WEST SUSSEX COUNTY COUNCIL CONSULTATION

TO:	Arun District Council FAO: David Easton
FROM:	Stephen Gee Highways, WSCC
DATE:	17/05/2018
LOCATION:	Land at, Bilsham Road, Yapton
SUBJECT:	Y/91/17/OUT Outline application for the development of up to 250 residential dwellings (Class C3), vehicular access, public open space, ancillary works and associated infrastructure. Departure from the Development Plan. More information.
DATE OF SITE VISIT:	1 st September 2017, 20 th April 2018
RECOMMENDATION:	☐ Advice ☐ Objection ☐ Modification ☐ No Objection ☐ More Information ☒ Refusal
S106 CONTRIBUTION TOTAL:	£ See below for breakdown.

Scale 1:500 @A1	Date DEC 17	Designed SD
Drawn SD	Checked MS	Approved R.JH
Job No 14-111	Drawing No 14-111/202	Rev

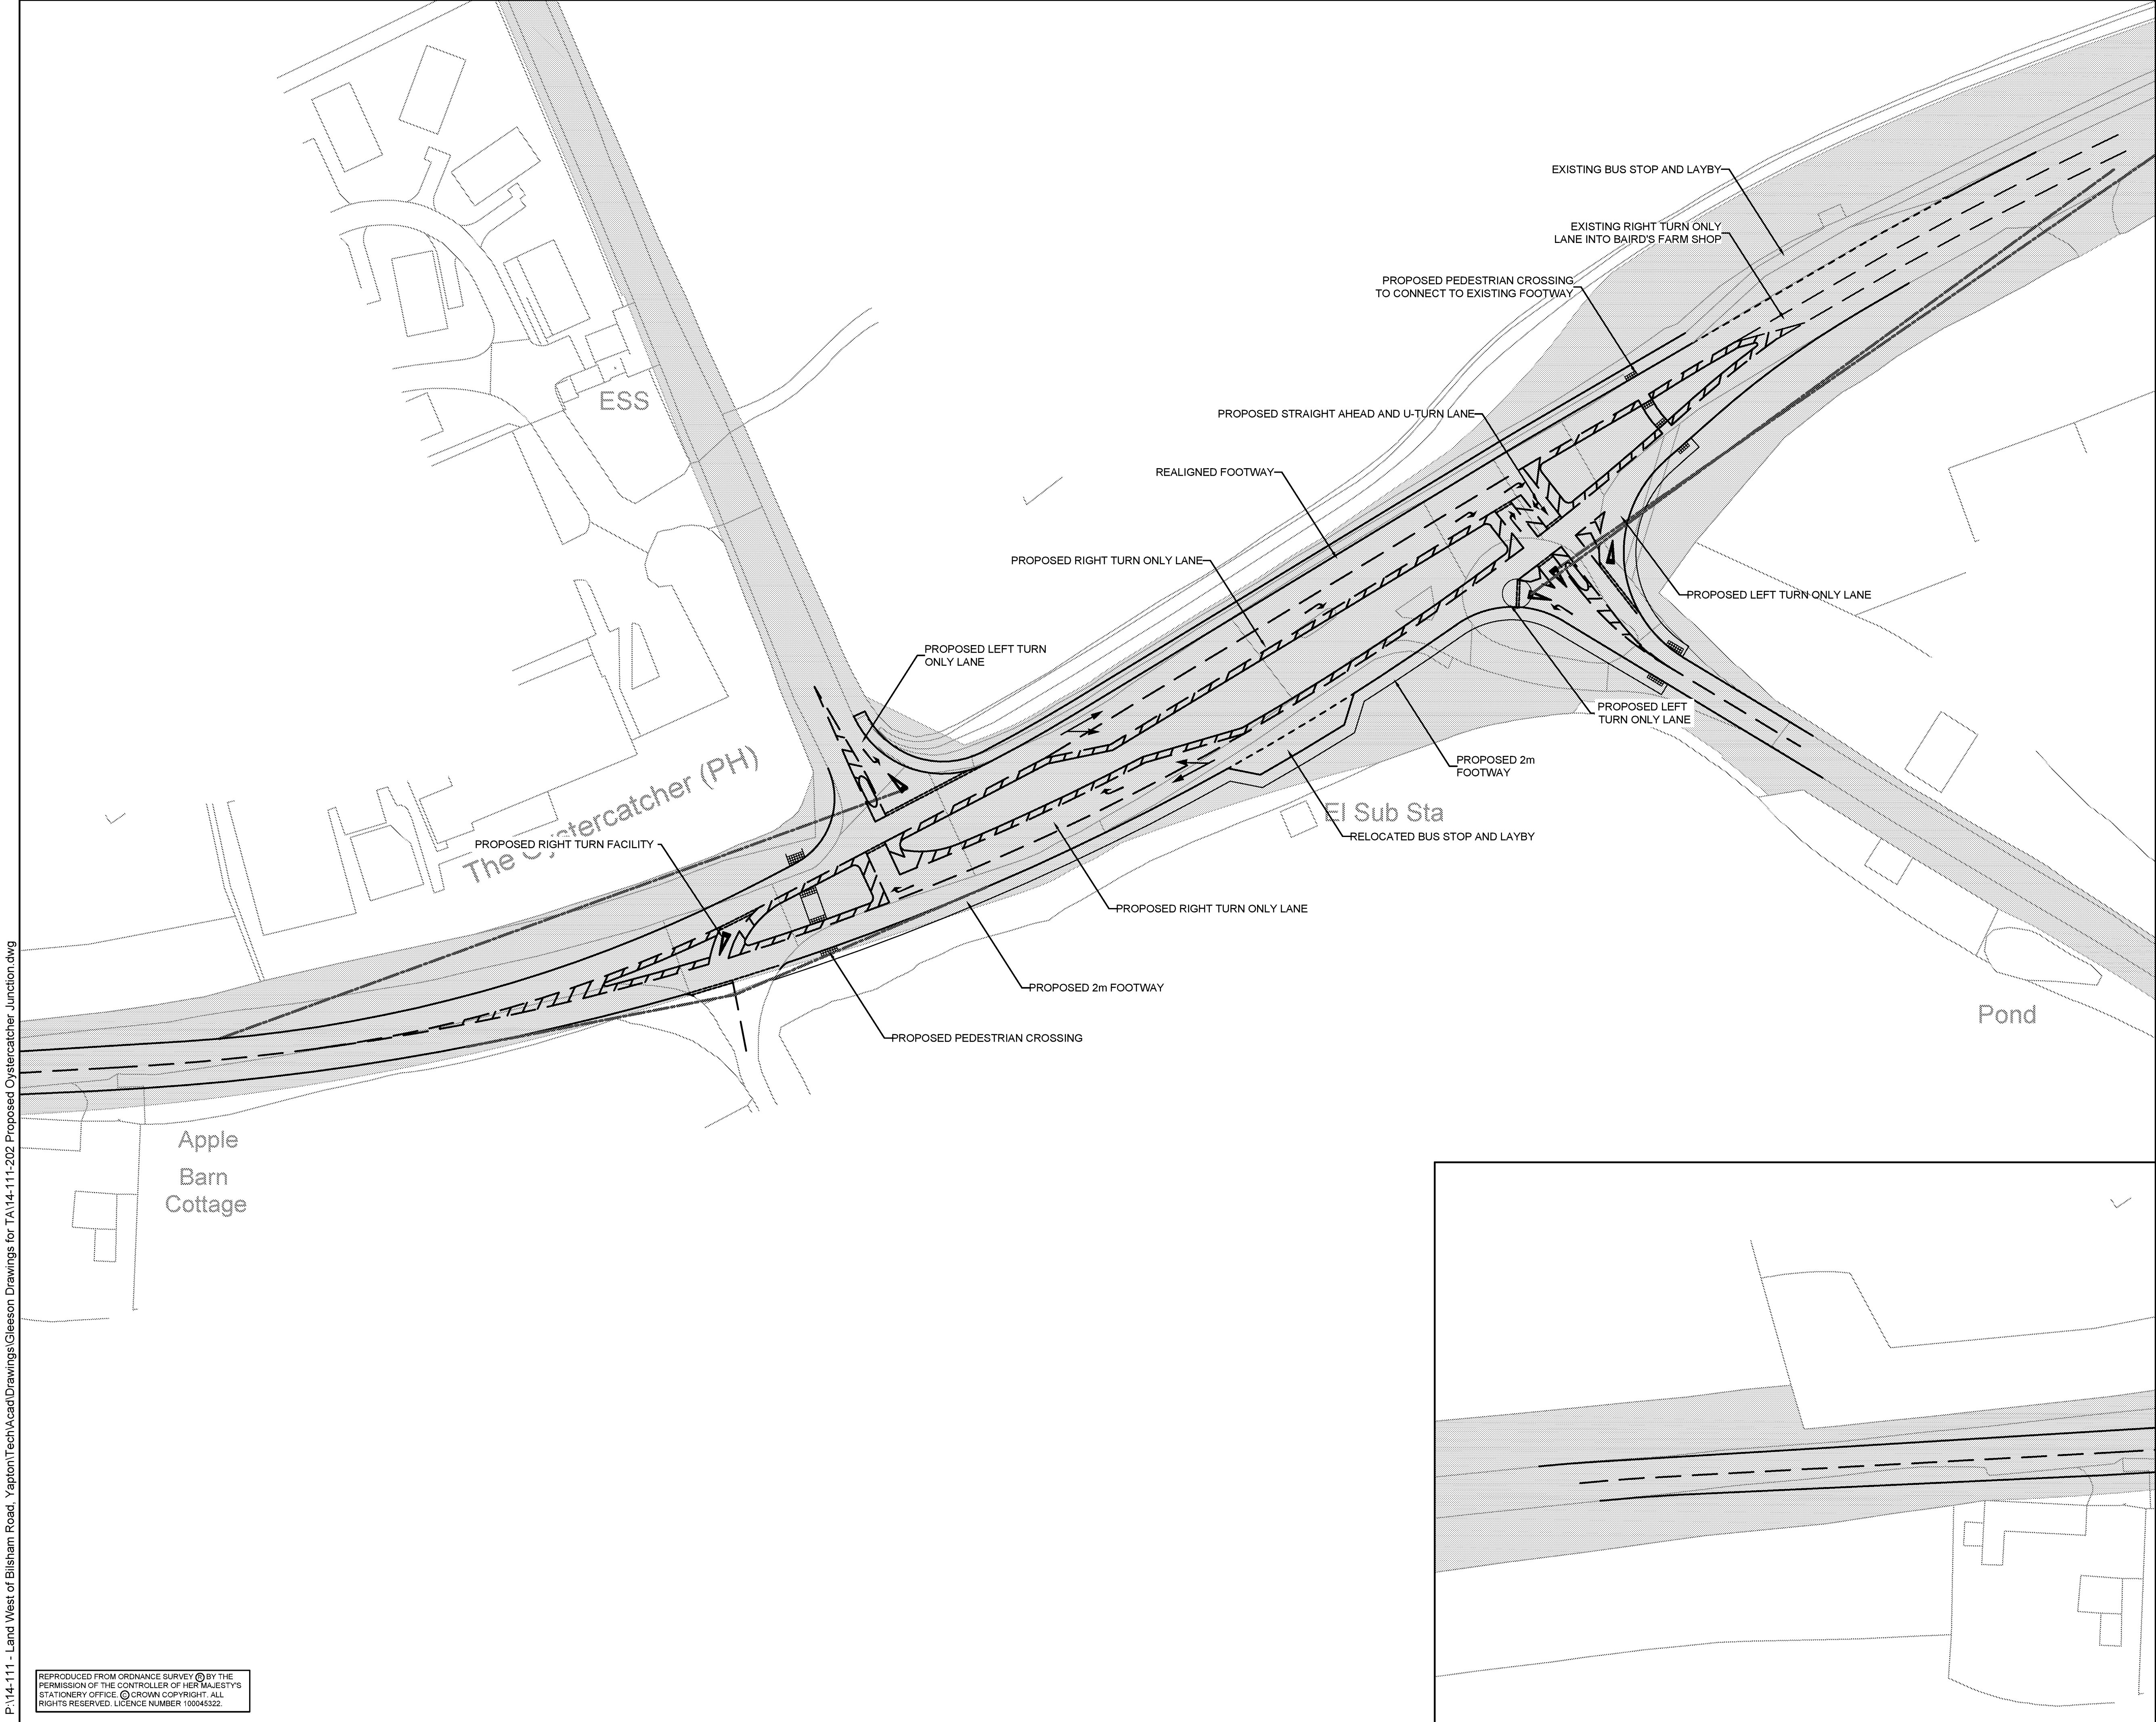
A design audit has not been undertaken on the proposals nor any departures proposed. From an initial look a number of issues are highlighted including:

- Left turns onto minor roads must have a nearside auxiliary lane or a nearside diverging taper;
- Acceleration Lanes;
- Proposing a 40mph speed limit; and
- Lane widths and central reservation widths.

It should also be noted there are lots of stats in the area which have the potential to be affected by the scheme.

Due to these issues a full modelling review has not been undertaken.

It should be noted that the preferred solution for the junctions as highlighted in the Arun Transport Strategy Stage 3 report is a roundabout at Oyster Catcher and junction Improvement at Comet Corner is suggested that an appropriate contribution is agreed with the applicant to deliver an improvement to both Oyster Catcher and Comet Corner.
